Application No: WA/70/20/DOC
Site Address: Land East of Tye Lane Walberton
Description of works: Approval of details reserved by condition imposed under ref WA/44/17/OUT relating to Condition No 6 - Construction Management Plan.

Thank you for your internet representation made on 22nd October 2020 which has been recorded as an objection with the comments as follows:

Scale AS SHOWN	Date MAY 2020	Designed by KI
Drawn by KI	Checked by DH	Approved by KM
Drawing Number 183244-001		Rev -

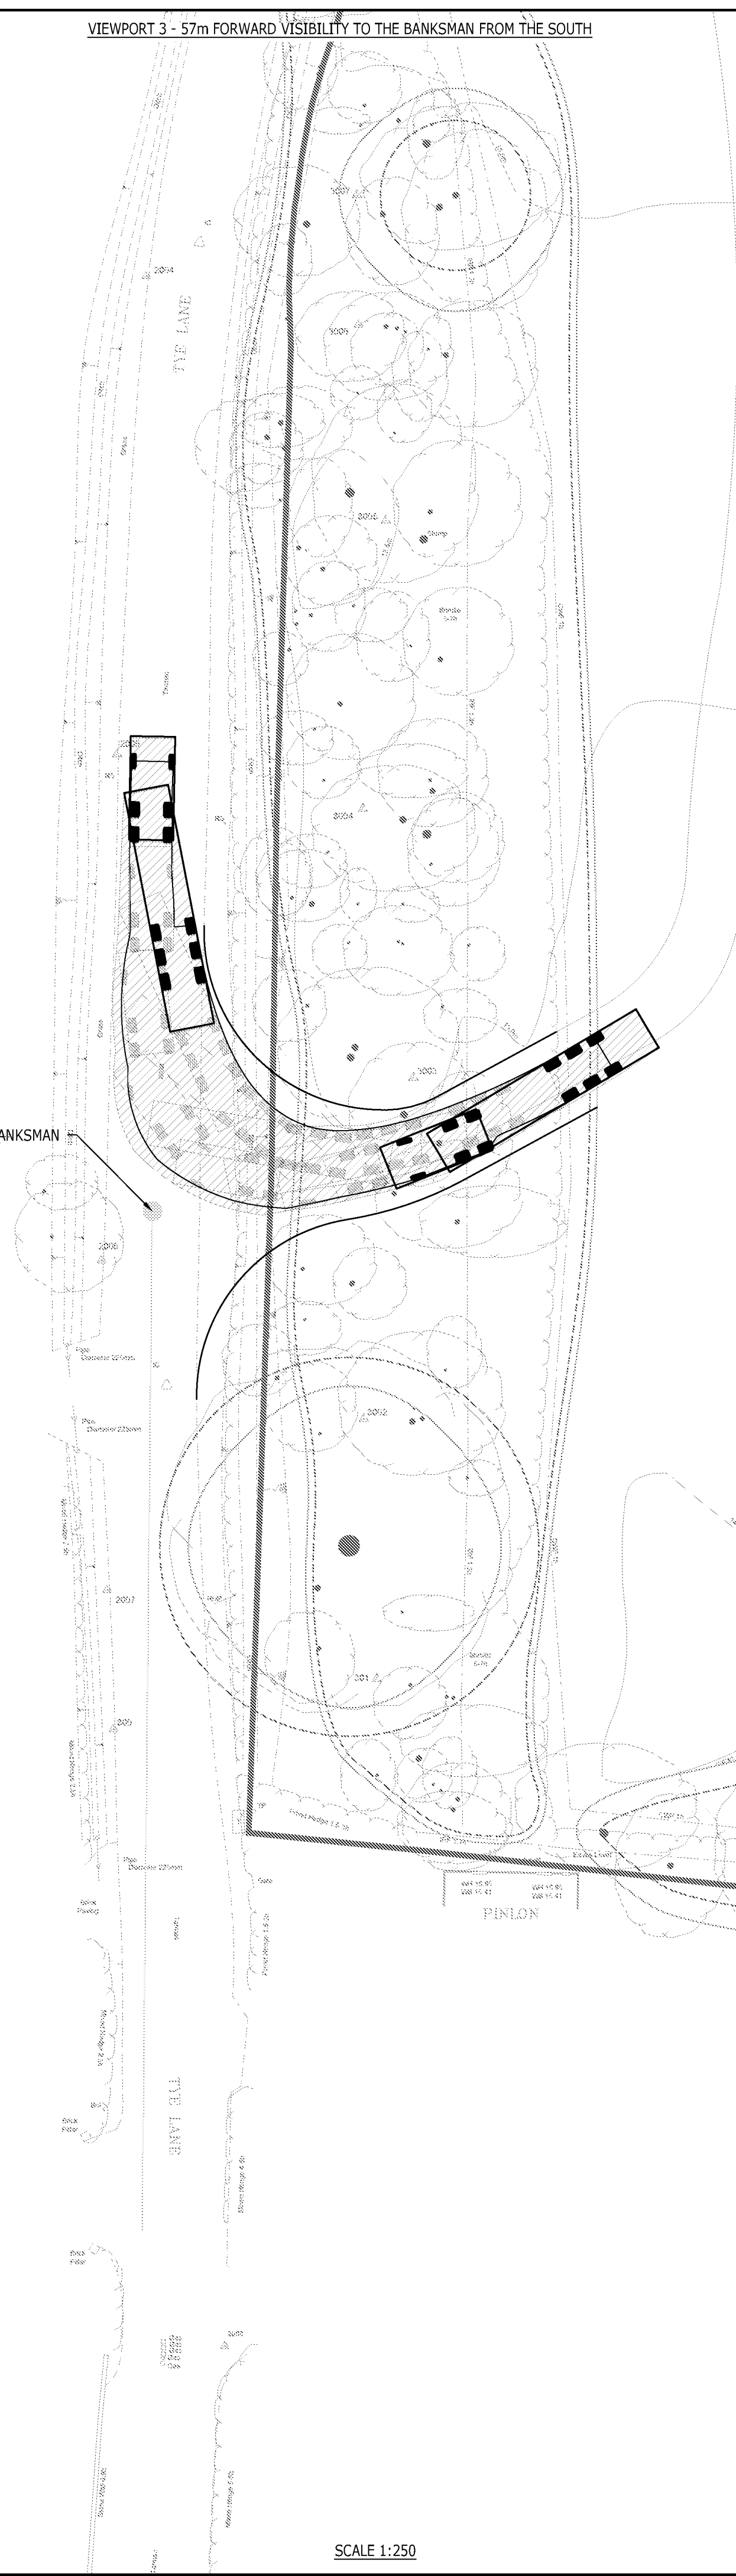
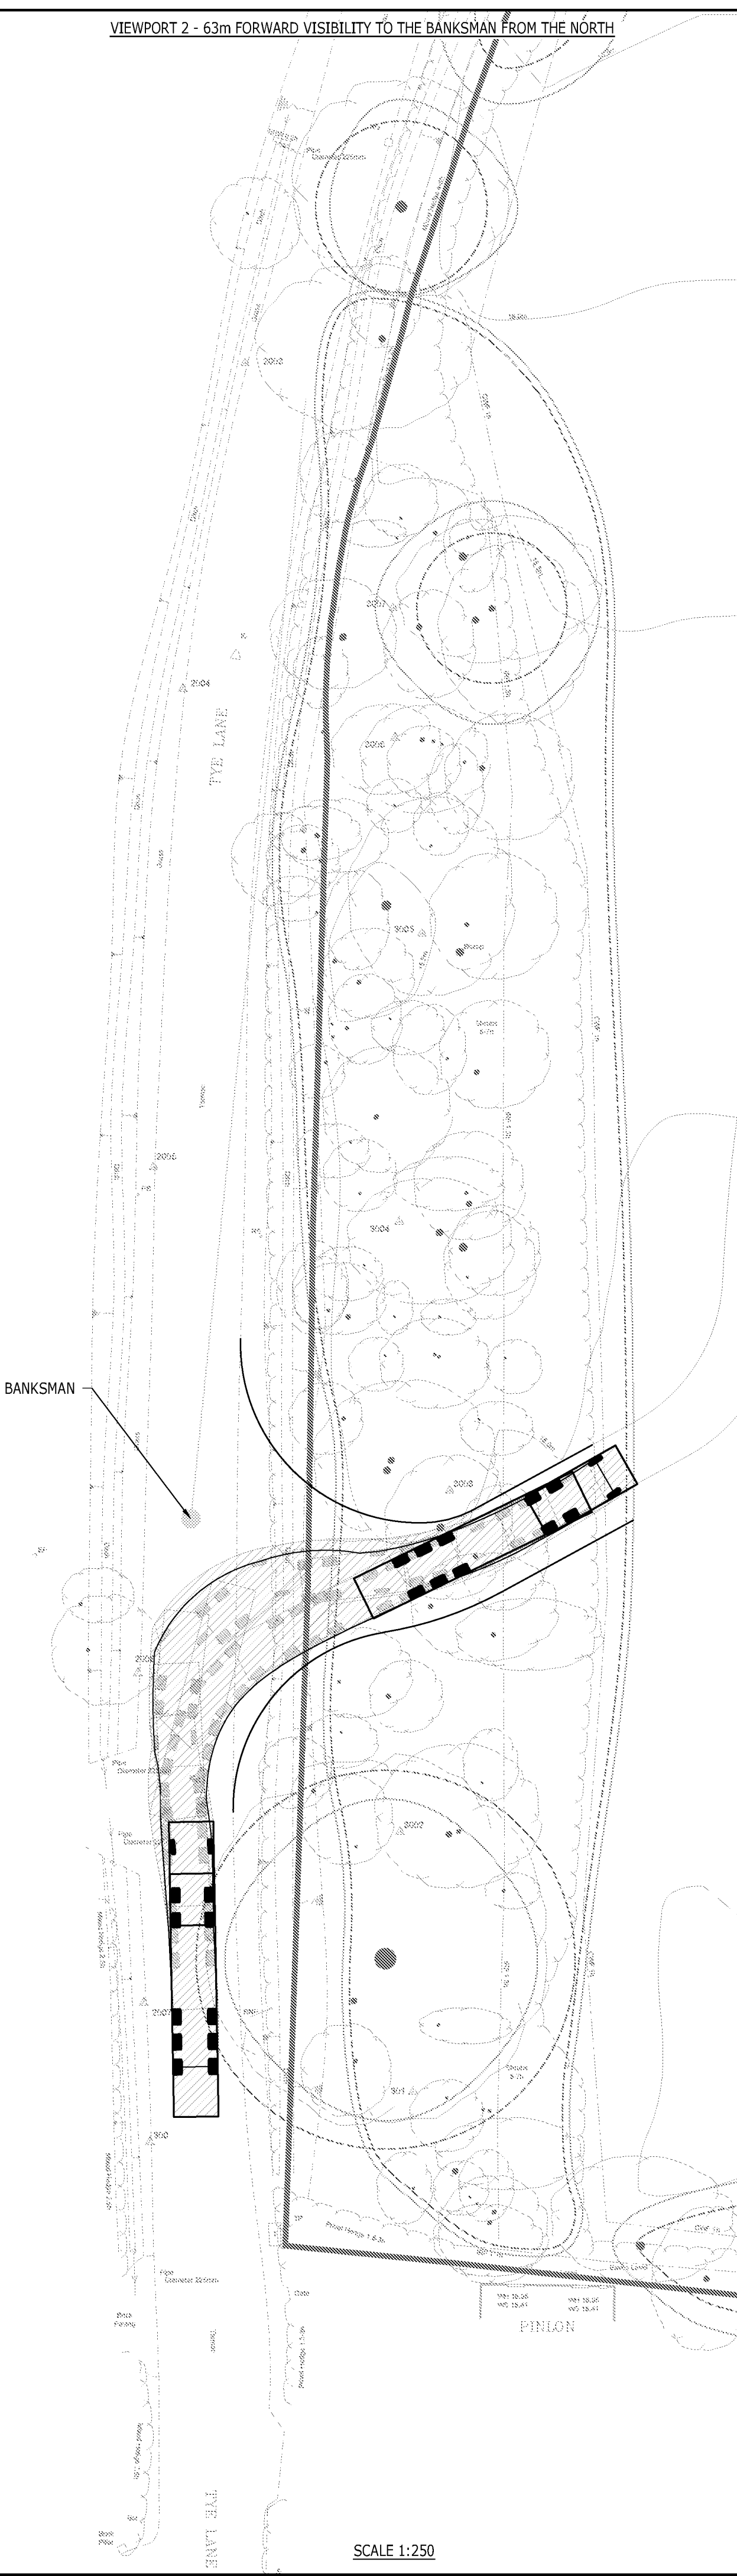
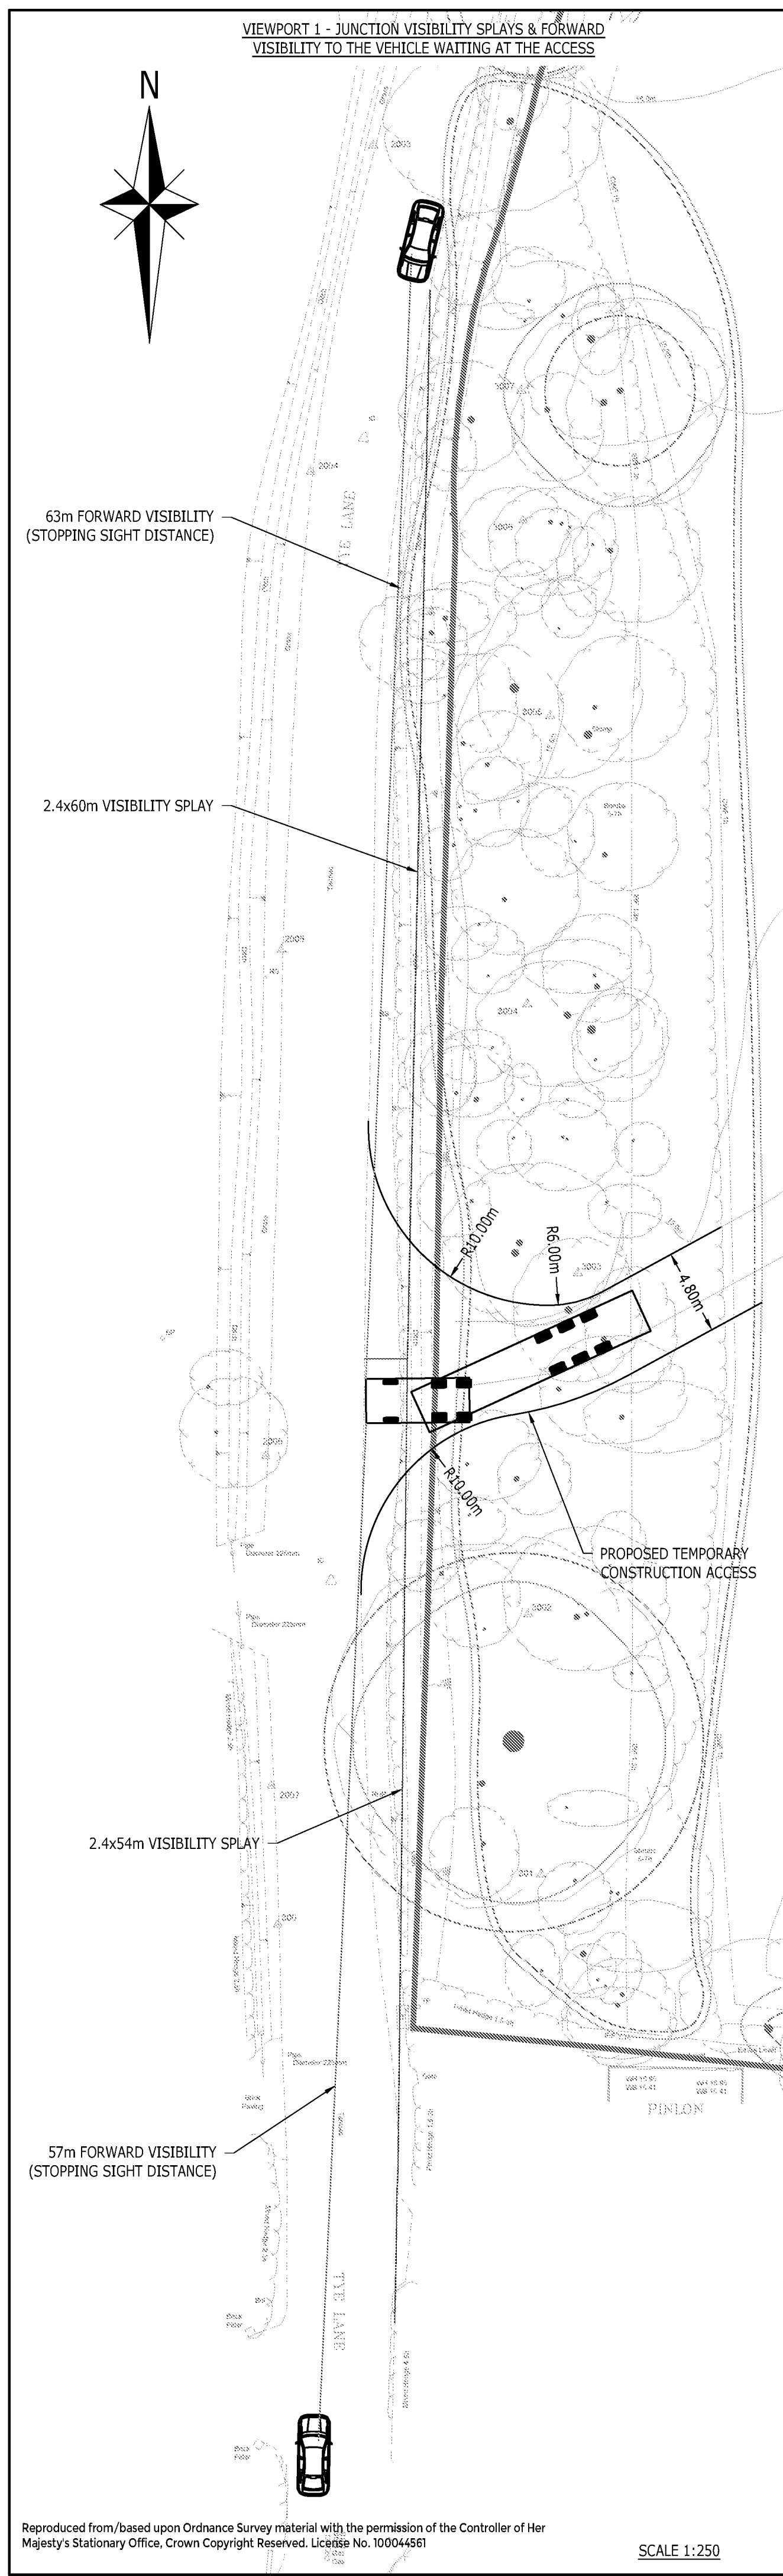
Although Tye Lane is limited to 7.5 tonnes except for access this regulation is frequently ignored by HGVs. Many vehicles also drive at excessive speed. I endorse the statement made by Ardent Consulting Engineers, ACE, (Vehicle type and movements report (s4.24 construction access arrangements) stating ' - drivers/vehicles prohibited from accessing the site from the south ... ' The direction of access should only be allowed from the north, whatever the size, and all vehicles should return the same way. I am also particularly concerned that any site access does not impinge on my house entrance. Has this been considered? I observe that the outline of my property (The Orchard) does not appear on the map showing sweep in access

from both north and south.
